ADC Planning Consultation Conservation/Design Officer Response

Application Number	A/64/17/DOC
Address	Land r/o 1 - 6 The Cottrells, Angmering
Description	Conditions imposed under A/173/16/PL relating to Condition 3 - Schedule of materials
Case Officer	Anita Gardner
Date	11 May 2017

Rev	Description	Date
Job Reference		Client
New House The Cottrells Angmering		AM Homes Ltd
Drawing Title		Drawing No
Hard & Soft Landscaping Plan		AD962/02
Date	Scale	Dwg Size
26.02.17	1:100	A3
Plot Style	Drawn	Checked
ADG/ryc/sk	TGG	AD

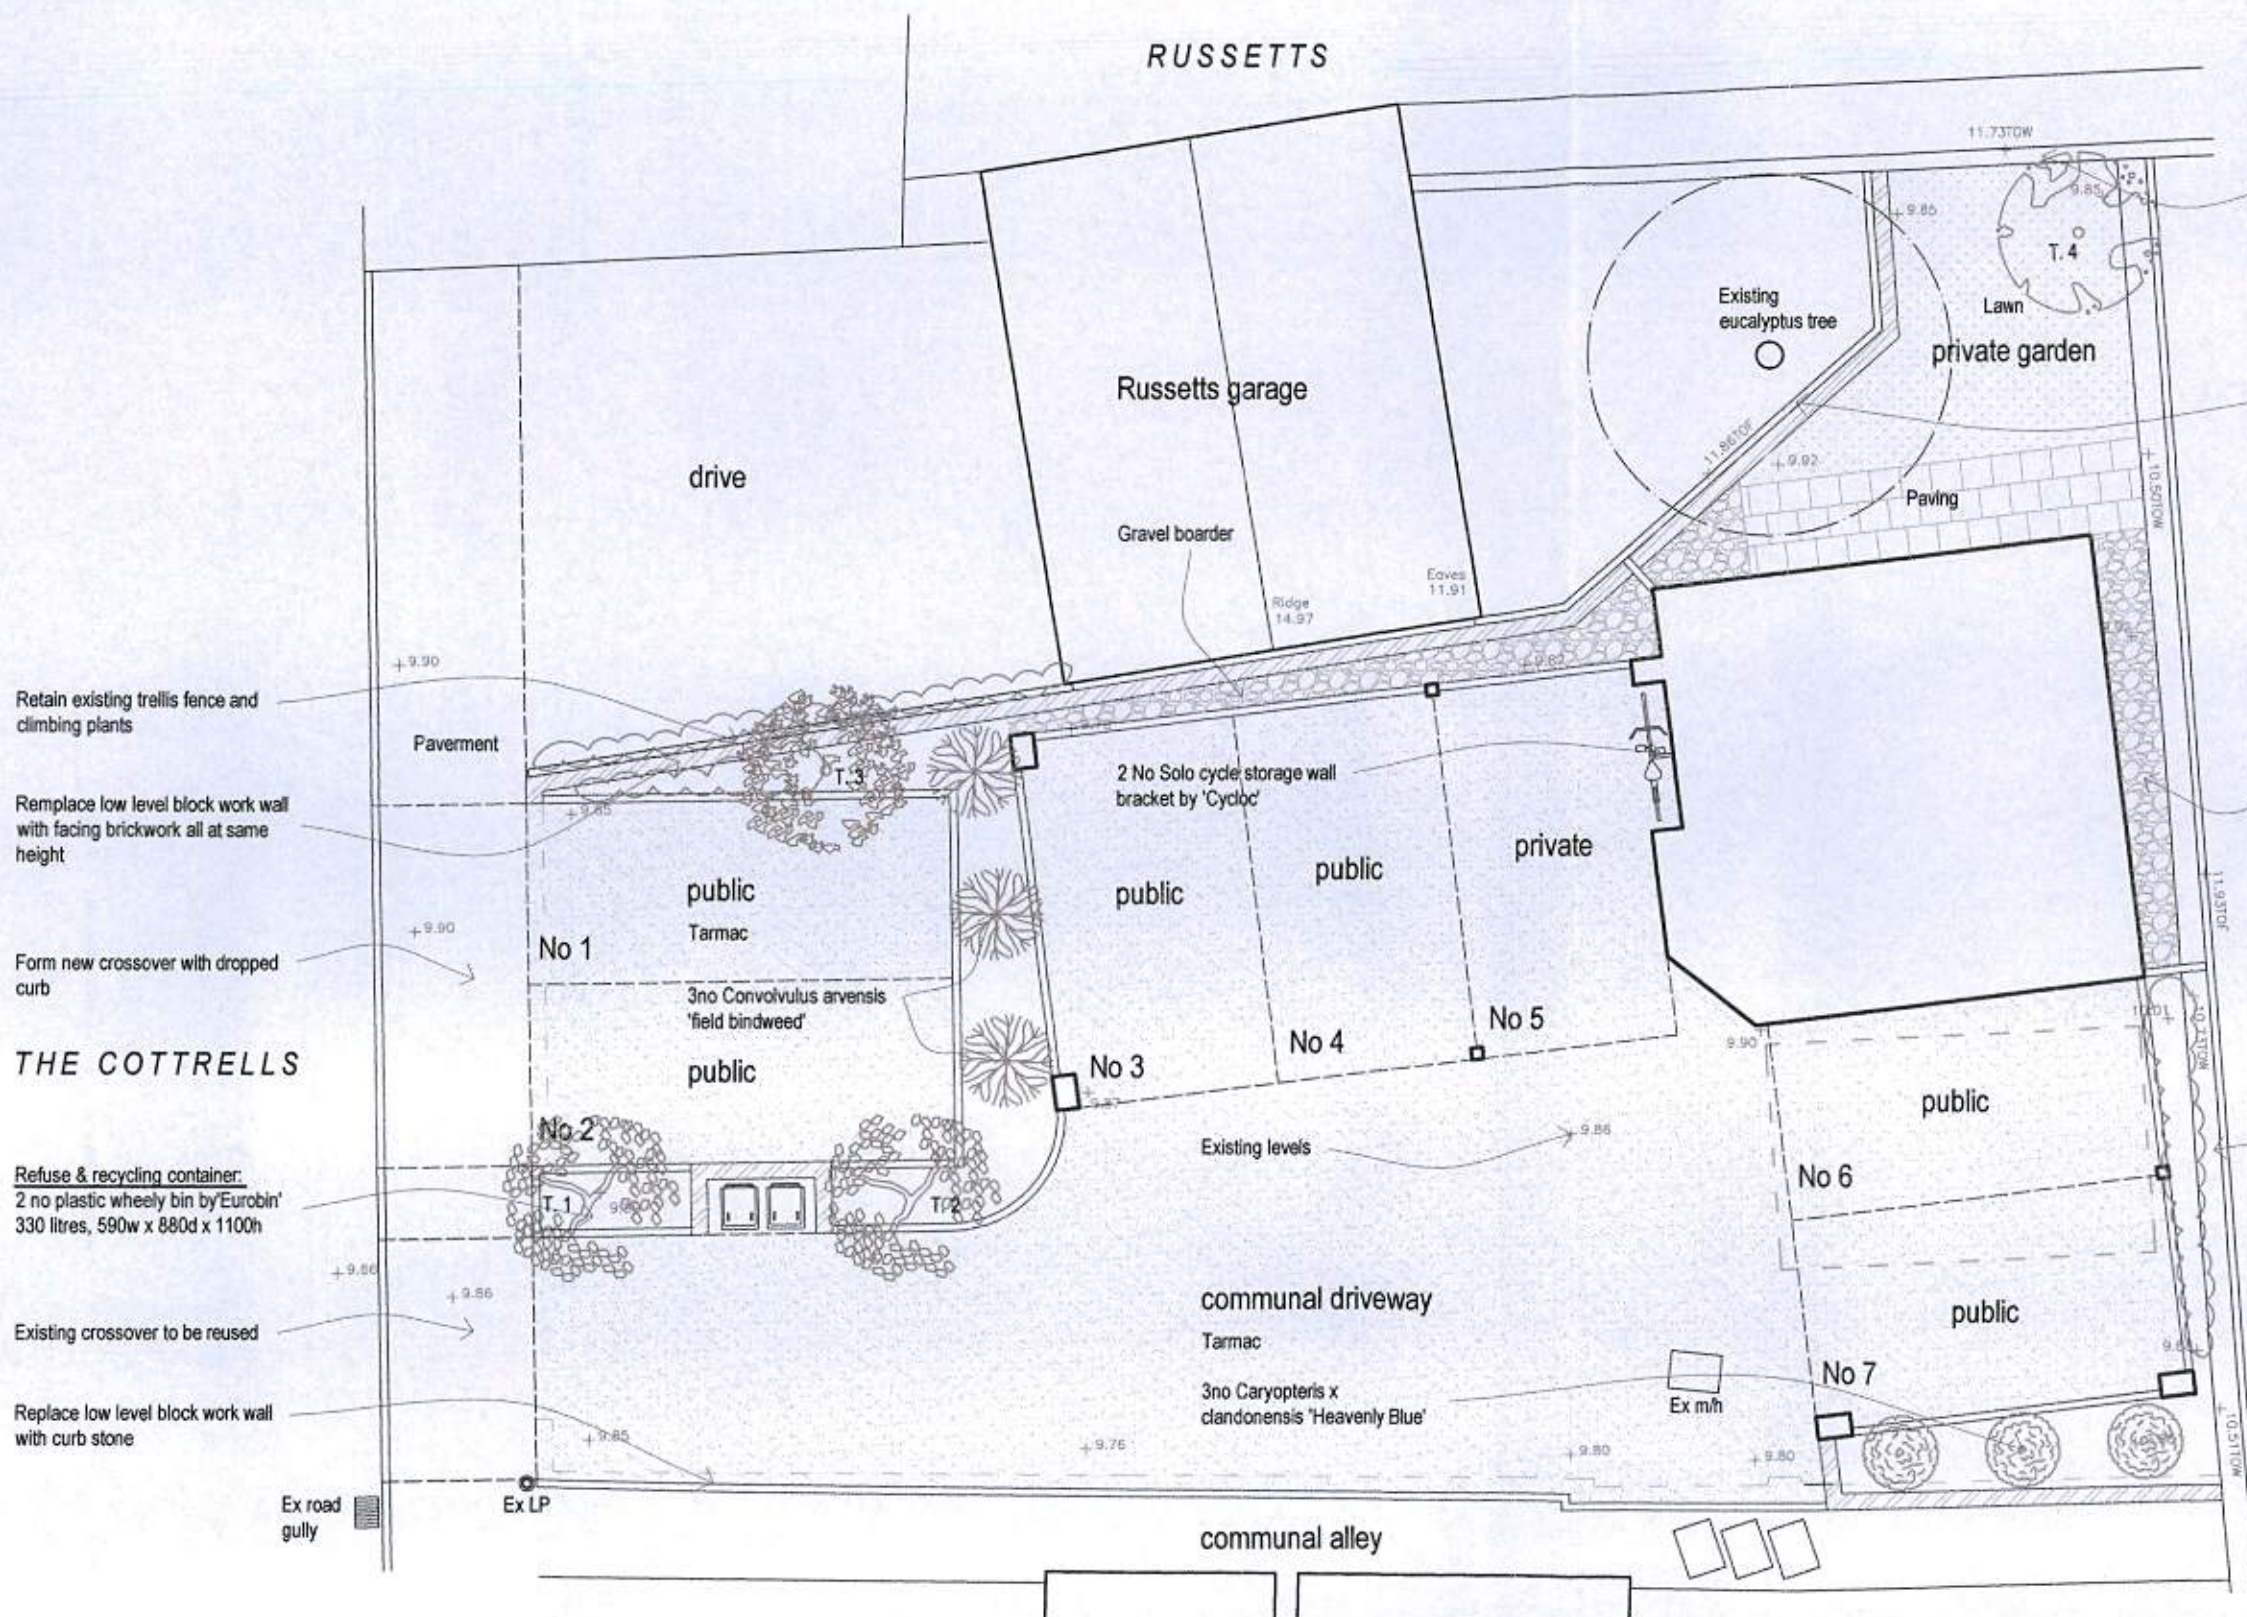
Some of the materials specified on the 'External Materials List' submitted to discharge the condition (A/64/17/DOC) are consistent with those approved under A/105/16/PL. However, there are a number of deviations:

Permitted under A/105/16/PL.	Proposed under A/64/17/DOC
Rain water goods & soffits: no material specified	UPVC
External wall finish: black stained timber boards	Cement boards
Windows and doors: timber	Aluminium
Driveway: block paving	Tarmac

The permitted building is of traditional scale form and style and it is located in the Angmering Conservation Area. In a context such as this, the use of good quality, traditional materials is expected and the various modern materials now proposed as alternatives are entirely alien to the context.

Many of the materials now specified are alien to the historic context and the condition cannot be discharged in terms of Policies D DM4 and HER DM3.
